From: Stephen Garrard
Sent: 26 February 2019 08:44
To: Arun
Subject: Planning Response - FP/30/19/PL

WEST SUSSEX COUNTY COUNCIL CONSULTATION

TO:	Arun District Council FAO: Stuart Corbey
FROM:	Highways, WSCC
DATE:	26/02/2019
LOCATION:	10 South Road, Felpham, PO22 8EF
SUBJECT:	FP/30/19/PL Demolition of chalet & erection of 1 No. 4 bedroom chalet (resubmission following FP/234/17/PL)
DATE OF SITE VISIT:	N/A
RECOMMENDATION:	☒ Advice ☐ Objection ☐ Modification ☐ No Objection ☐ More Information ☐ Refusal
S106 CONTRIBUTION TOTAL:	£ N/A

Site plan
10 South Road
Felpham
Scale 1:500

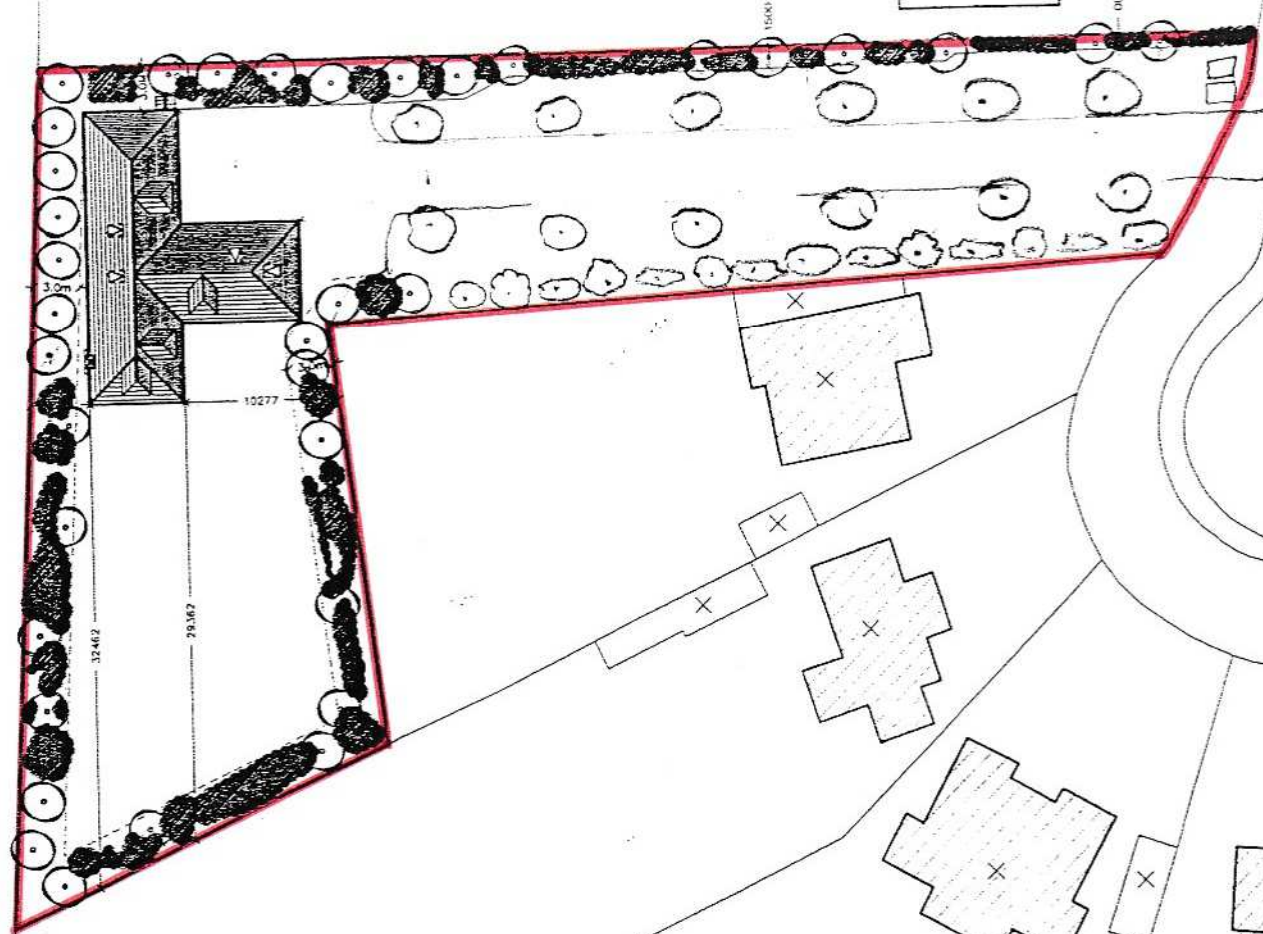
The applicant is proposing to relocate the existing access onto South Road; however this has not been clearly demonstrated on the proposed plans and does not demonstrate details of the closure of the existing access. However, details of this can be secured via condition. Local and WSCC mapping indicates that the crossover works may require the relocation of the street lighting pole located on publically maintained highway fronting the application site; this has not been demonstrated on the plans. These relocation works would need to be undertaken at the expense of the applicant. It is the responsibility of the applicant to liaise with the necessary parties to organise the moving of the street lighting pole. The pole will need to be relocated at least 1.5m from the location of the top of the ramped kerb of the proposed crossover.

The applicant has not demonstrated visibility at the proposed new access. WSCC mapping suggests that visibility in this location appears sufficient for the anticipated road speeds. Due to the no-through nature of the residential road, vehicles are not anticipated to be traveling at the posted speed limit in this location. Furthermore, an inspection of data supplied to WSCC by Sussex Police over a period of the past five years reveals that there have been no recorded injury accidents within the vicinity of the site. Therefore there is no evidence to suggest that the existing access has been operating unsafely or that the repositioning of the access would exacerbate an existing safety concern.

The WSCC car parking demand calculator expects that a minimum of 3 parking spaces would be required for a dwelling of this size and location. As the plan shows, there is more than adequate

parking on site, including the garage to accommodate the habitants. The proposed garage meets minimum internal specifications of 3 x 6m as set out in Manual for Streets (MfS).

The site is located within walking distance of local shops and services, including bus stops, primary and secondary schools, a leisure centre and a convenience store. Cycling is a viable option within the vicinity and as such, the garage should also provide secure cycle storage to support sustainable travel for the property.

No part of the development shall be first occupied until such time as the existing vehicular access onto South Road has been physically closed in accordance with plans and details to be submitted to and approved in writing by the Local Planning Authority.

No part of the development shall be first occupied until such time as the vehicular access has been constructed in accordance with plans and details to be submitted to and approved in writing by the Local Planning Authority.

No part of the development shall be first occupied until the vehicle parking spaces have been constructed in accordance with the approved plan. These spaces shall thereafter be retained for their designated use.

No part of the development shall be first occupied until the garage has been adapted to support both the amenities and sustainability of the property.
